PLANNING AMENDMENT

Application no: H16-0066-10

Description: Proposed UPVC front porch

Amendment: Amended roof covering (dwg. no. ATS/099-09-01B)

PROPOSED ELEVATIONS 1:100

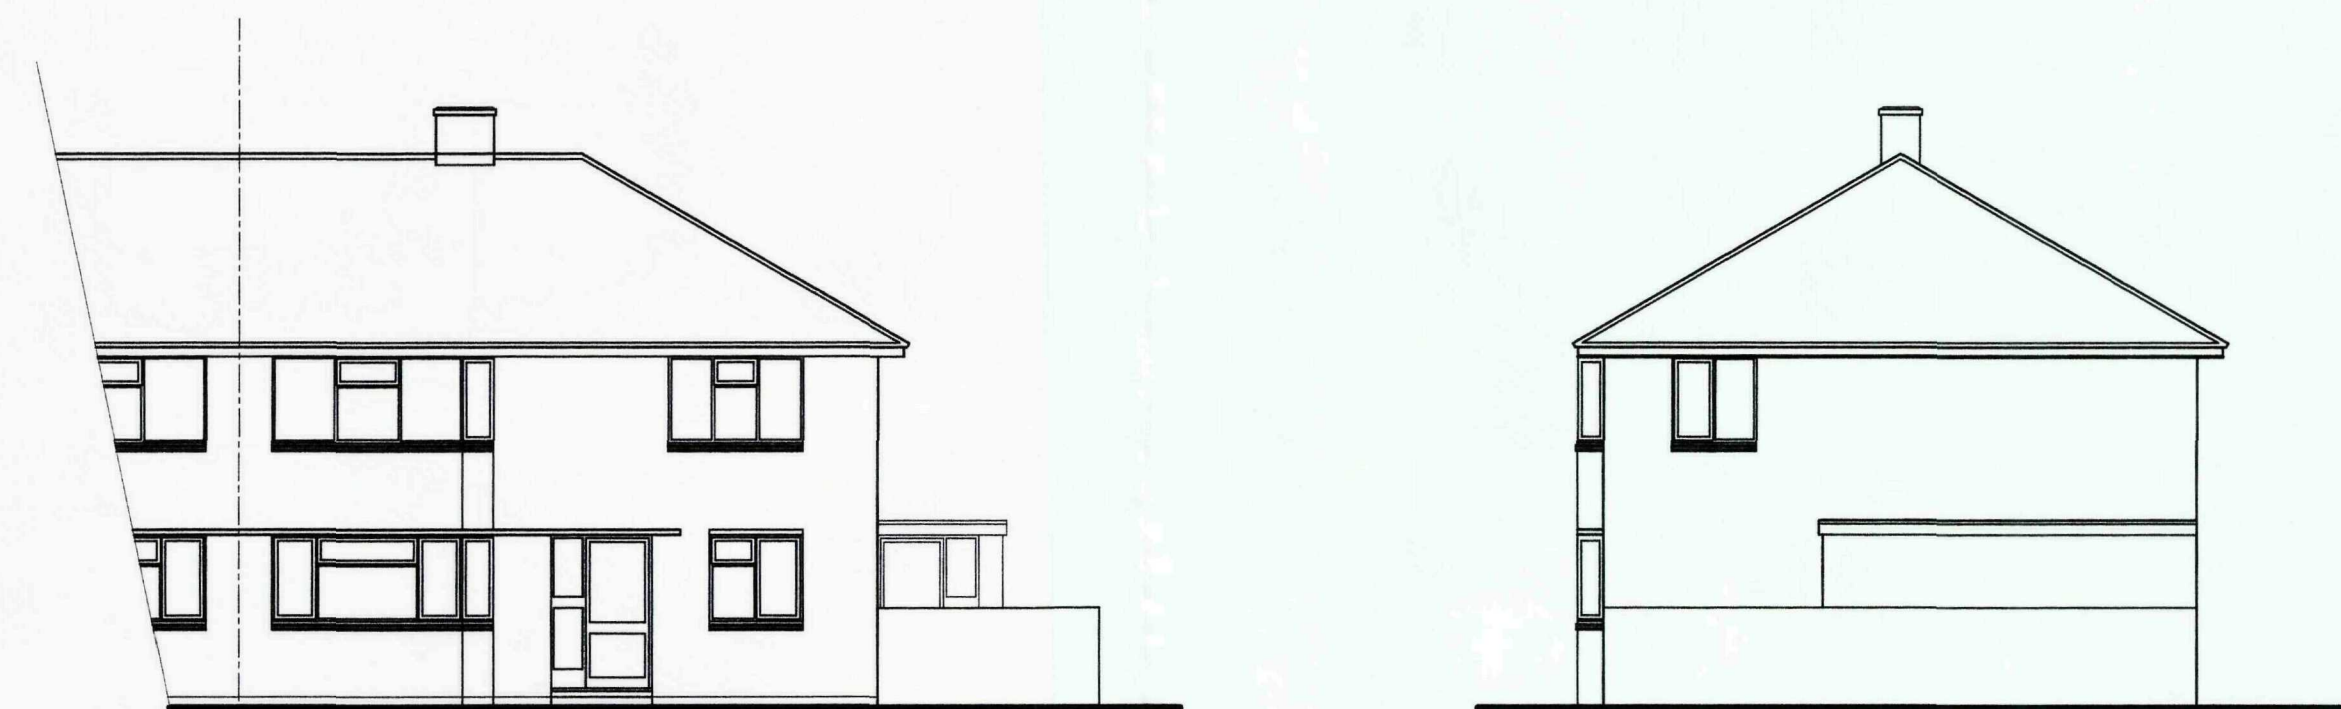
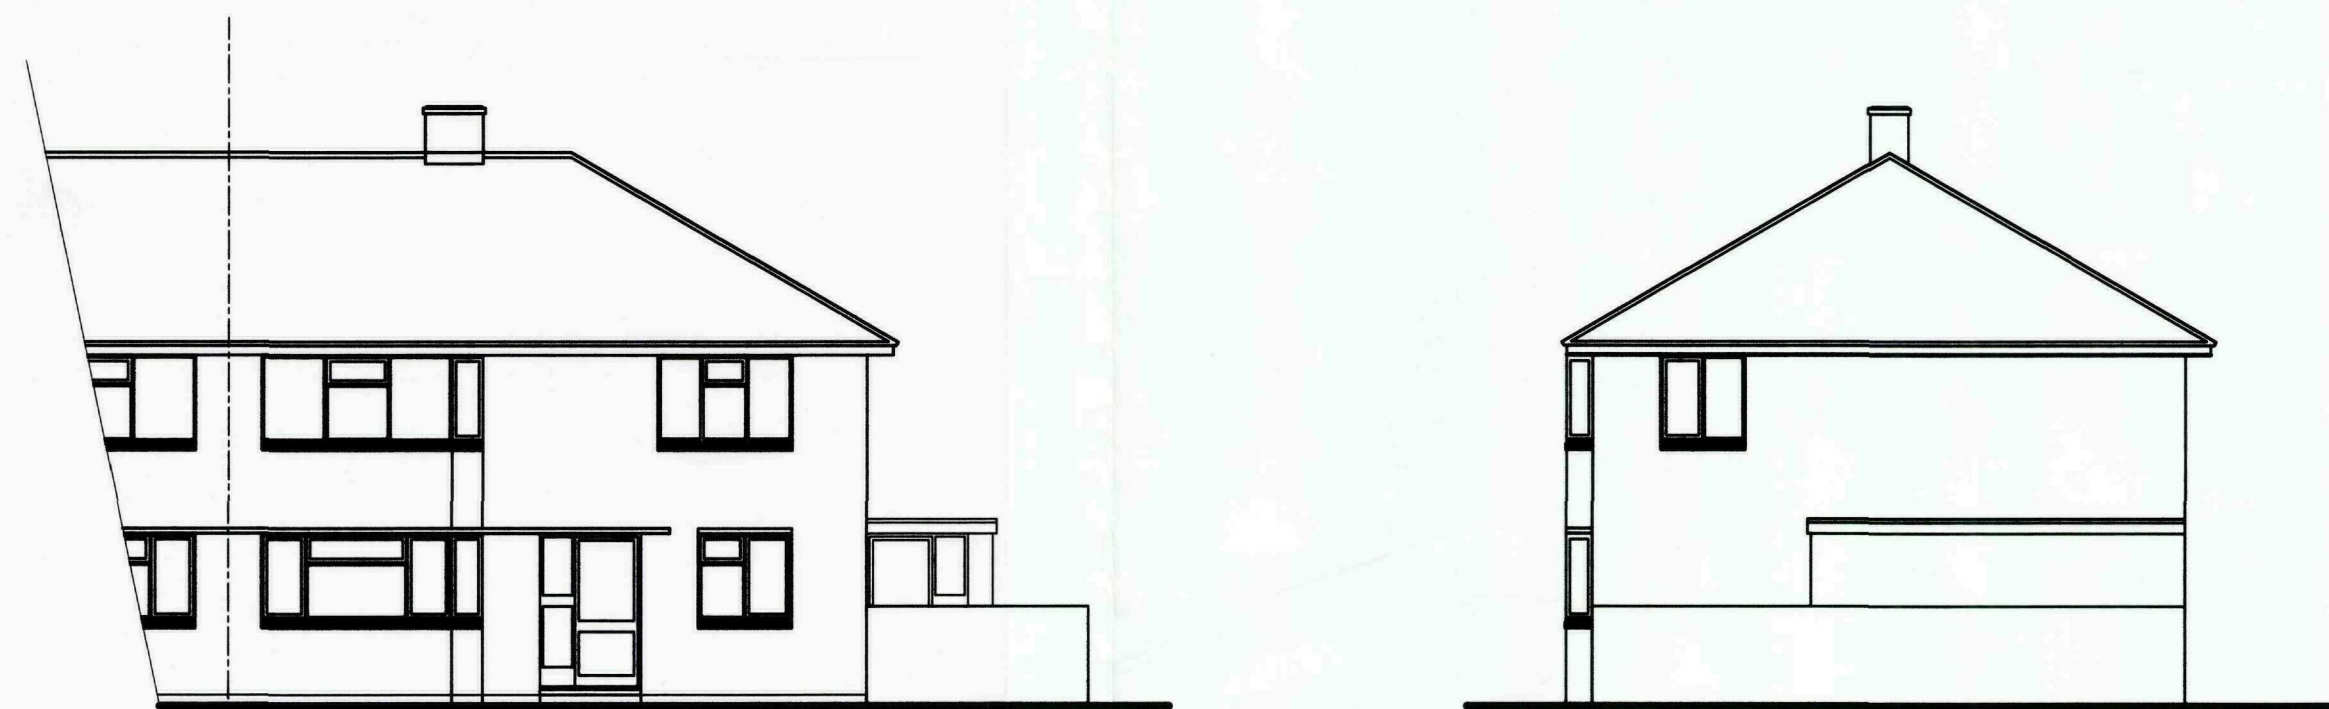
>
>
>
> Dear Shaun,
>
> I am writing in response to the plans submitted for the above address.
> The plans for the conservatory, although an improvement in the
> original lean-to design which was previously refused, still looks too
> much like a front conservatory. Would it be possible to change the
> materials to something more fitting to a front porch?

Please find attached the revised drawing showing the use of Decra Lightweight tiles - charcoal grey, as the roof covering.
